# MERIDIAN RANCH

DESIGN REVIEW COUNCIL NO. 1

RE: Improvement Plan, Lot 709

32' x 16' Patio Cover  
over Existing Concrete Patio

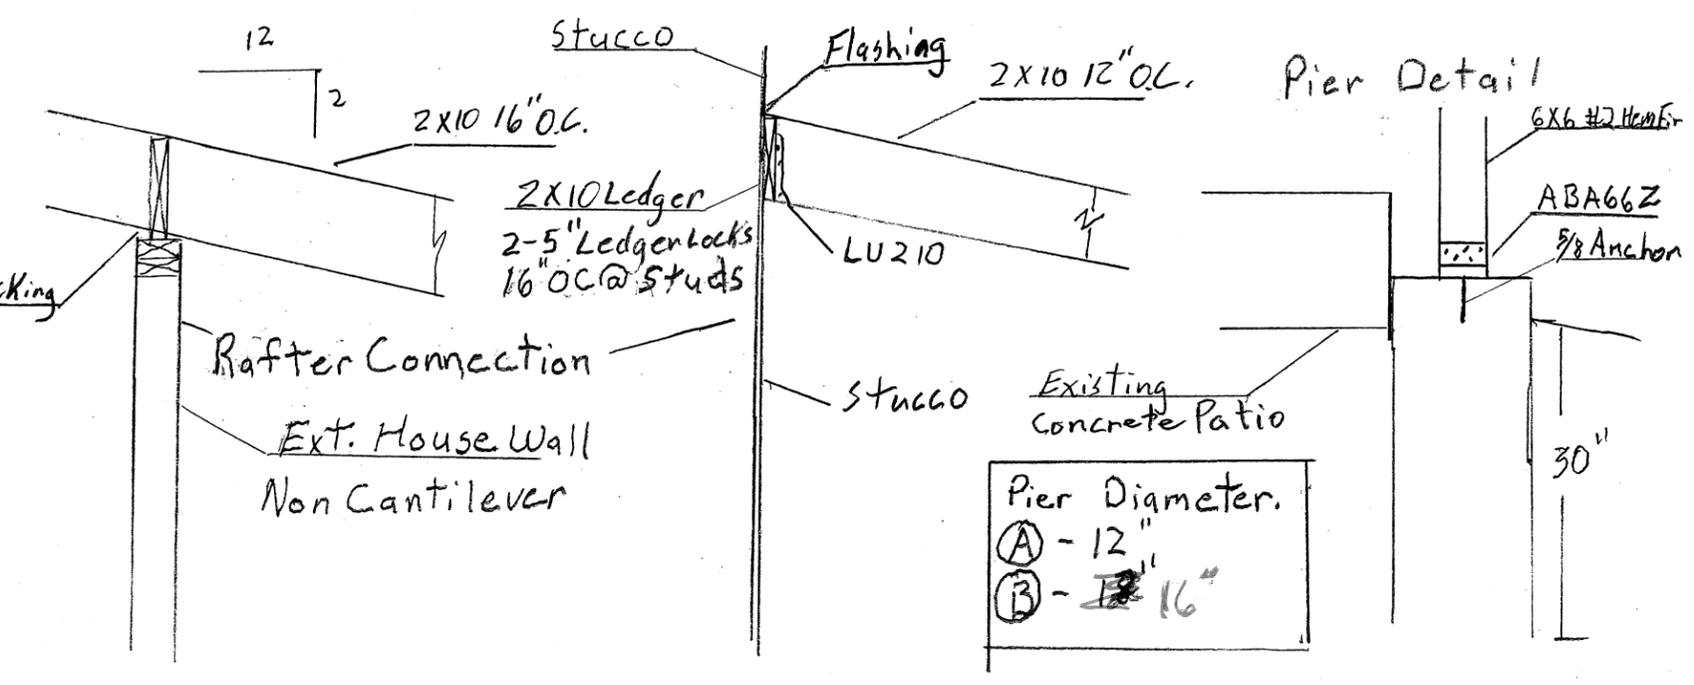
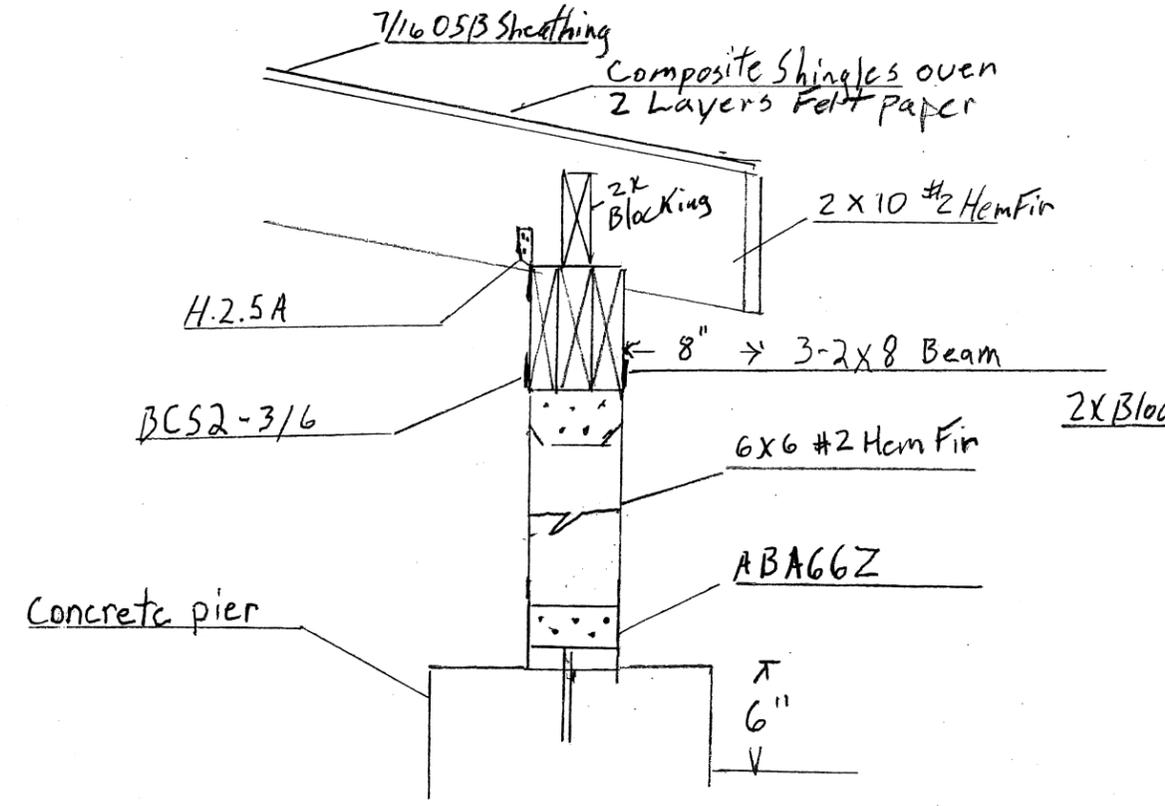
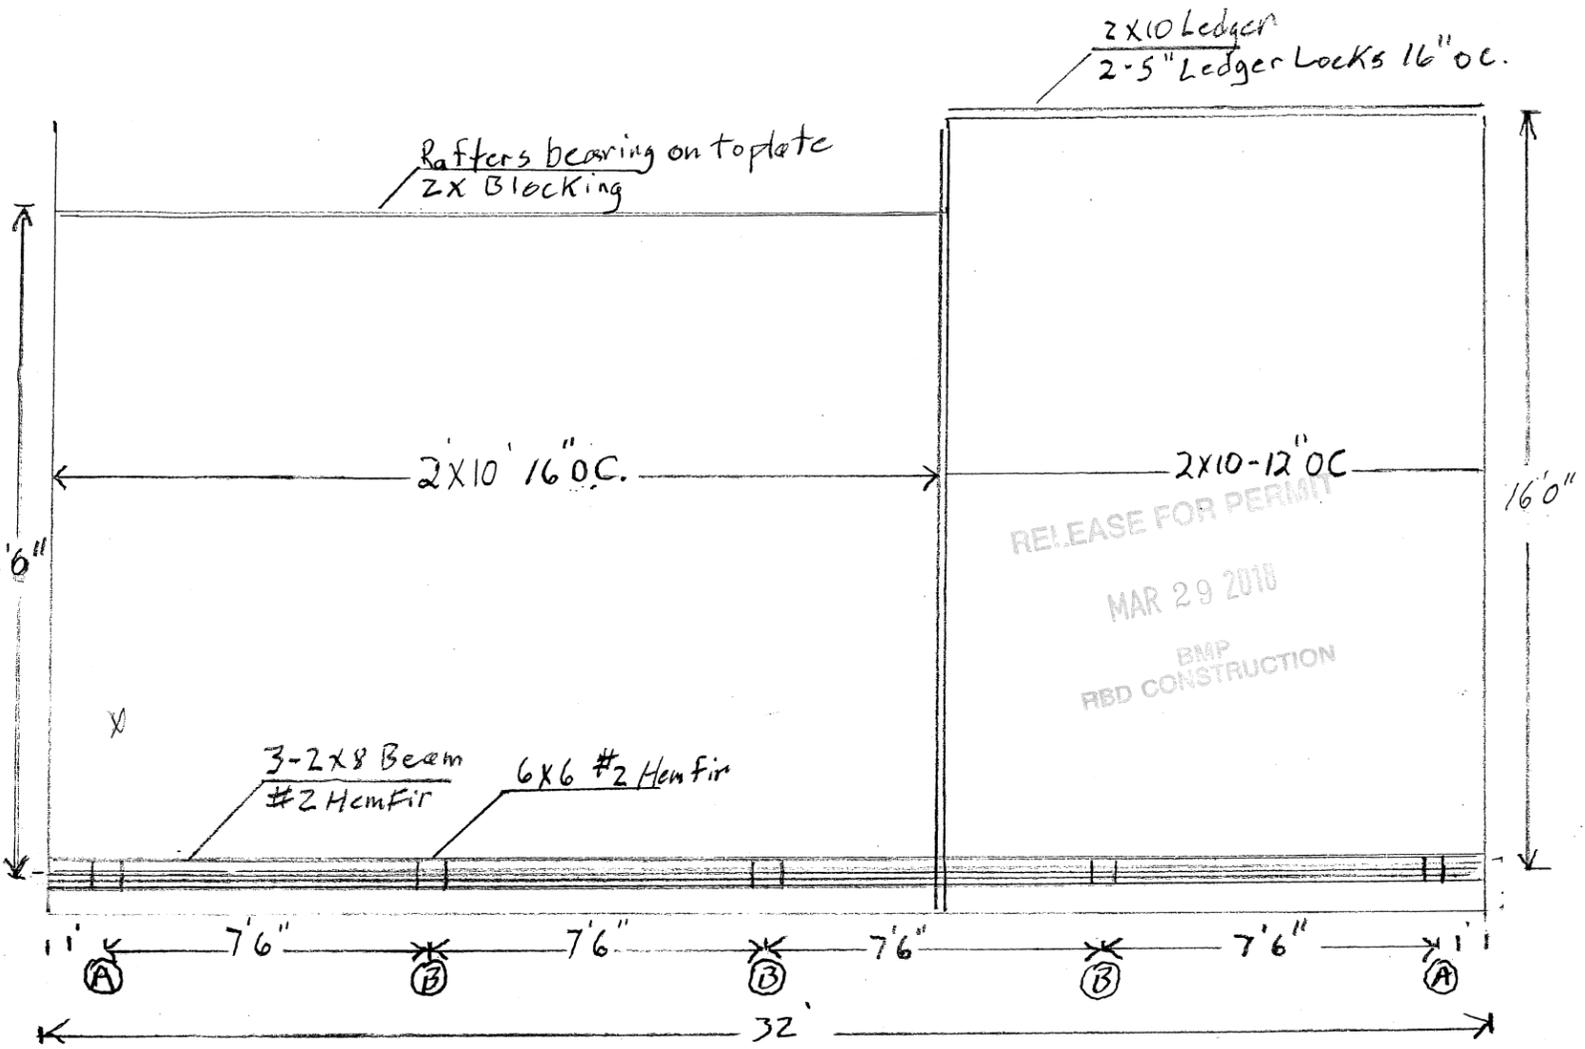
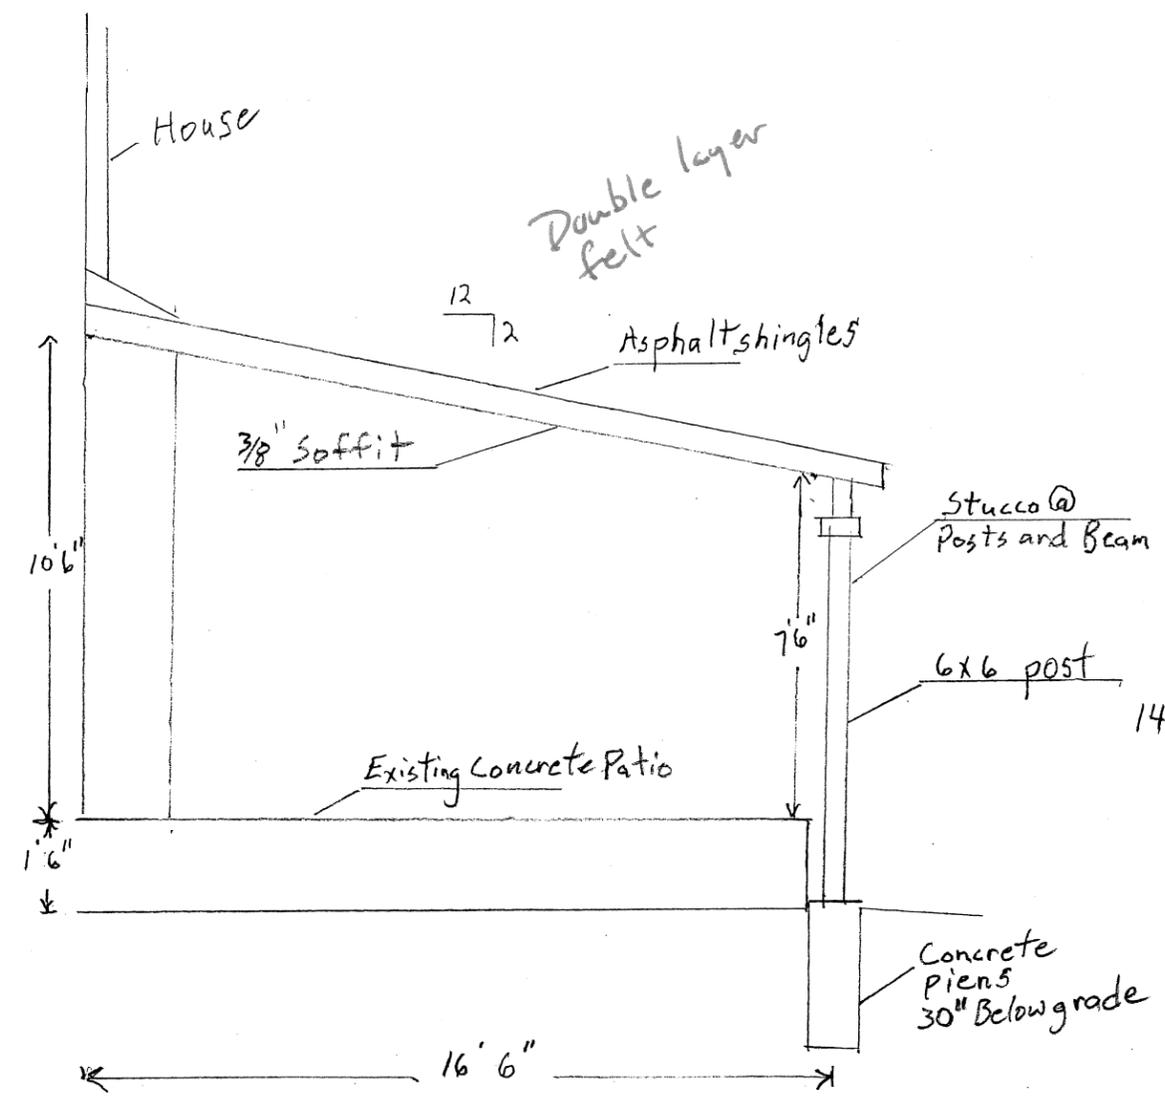
**Your patio cover has been approved as submitted.**

1. Elevated decks and balconies, including colors and materials, shall be consistent with the main structure and not appear tacked on.
2. **All vertical elements (deck railings, supports, and columns) fascia and overhead structures shall be painted or stained to match or compliment the main structure.**
3. Exterior stairs or steps shall not project out from a home or deck for more than 4 risers from the deck or home without a 90-degree turn after the 4<sup>th</sup> riser.
4. Exterior stair landings shall not project out perpendicularly into the yard.
5. For columns and supports refer to Exhibit 4 or 5.
6. **Prior to building, check with county regarding whether a permit is required.**
